**Application by Thurrock Power Limited for an Order  
granting Development Consent for the Thurrock Flexible Generation Plant**

**Planning Inspectorate Reference: EN010092**

**WRITTEN REPRESENTATION AND RESPONSE TO FIRST WRITTEN QUESTIONS  
BY PORT OF TILBURY LONDON LIMITED (POTLL)**

**23 March 2021**

Figure 1.1 Proposed causeway structure.

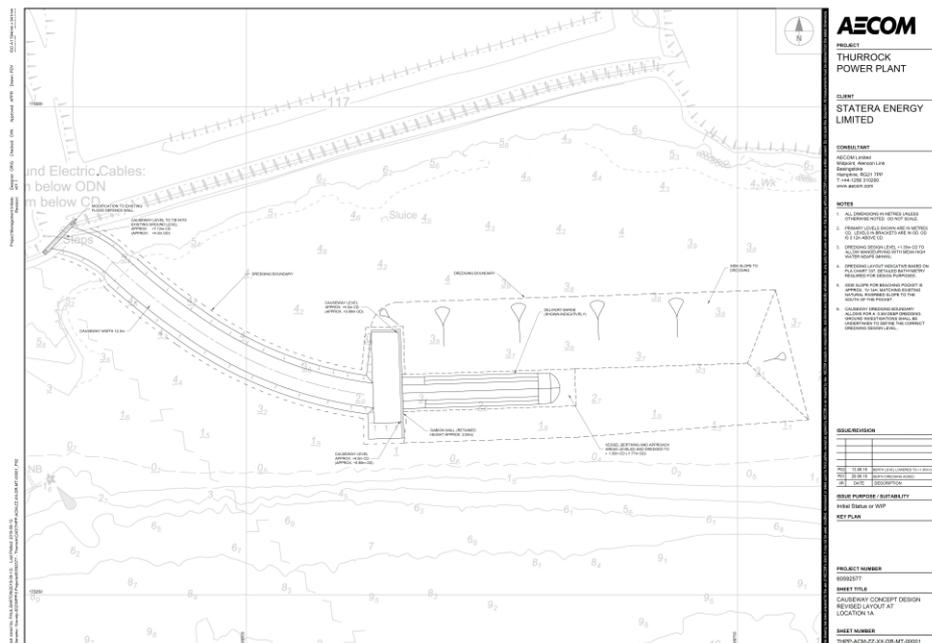
- 2.1 As stated in paragraph 48 of its Relevant Representation [RR-023], PoTLL objects to the proposed causeway in the river Thames. In support of this objection, PoTLL notes the following matters:

- 2.4.3 security issues having to be considered by RWE in terms of footpath users trying to access the causeway; and
  - 2.4.4 the identified short term impacts to saltmarsh and intertidal mudflat habitat.

- 2.5 In respect of the final point, PoTLL is particularly concerned that the affected saltmarsh is directly adjacent to the saltmarsh and intertidal habitat that PoTLL is required to manage as part of 'Compartment 10' of the Landscape and Ecological Management Plan that PoTLL is required to comply with under the Port of Tilbury (Expansion) Order 2019 ("the Tilbury2 DCO") (see further

- 2.7 In this context, and its location adjacent to existing port uses at Tilbury2, PoTLL considers that the causeway would reduce or sterilise the potential of this land by significantly reducing the amount of river frontage that would be able to be utilised (both because of the causeway itself and movements to and from it) to support any development that were to take place on the land.

- 2.10 It is therefore considered that the Applicant should withdraw its proposals for the causeway and bring forward an alternative proposal for AILs access as soon as practicable and in any event by the next Examination Deadline.

- 2.11 In this context, PoTLL and RWE have been working with the Applicant to develop an alternative AILs access proposal which would involve constructing a track from Fort Road to connect to the access road through Tilbury2 ('Substation Road') and then on into RWE's land utilising Substation Road, and then curving up into the power plant site.

- 2.12 As this is an option that is acceptable to all parties, it is PoTLL's view that the Applicant should forthwith be bringing forward a change request to remove the unacceptable causeway and to facilitate this alternative proposal.
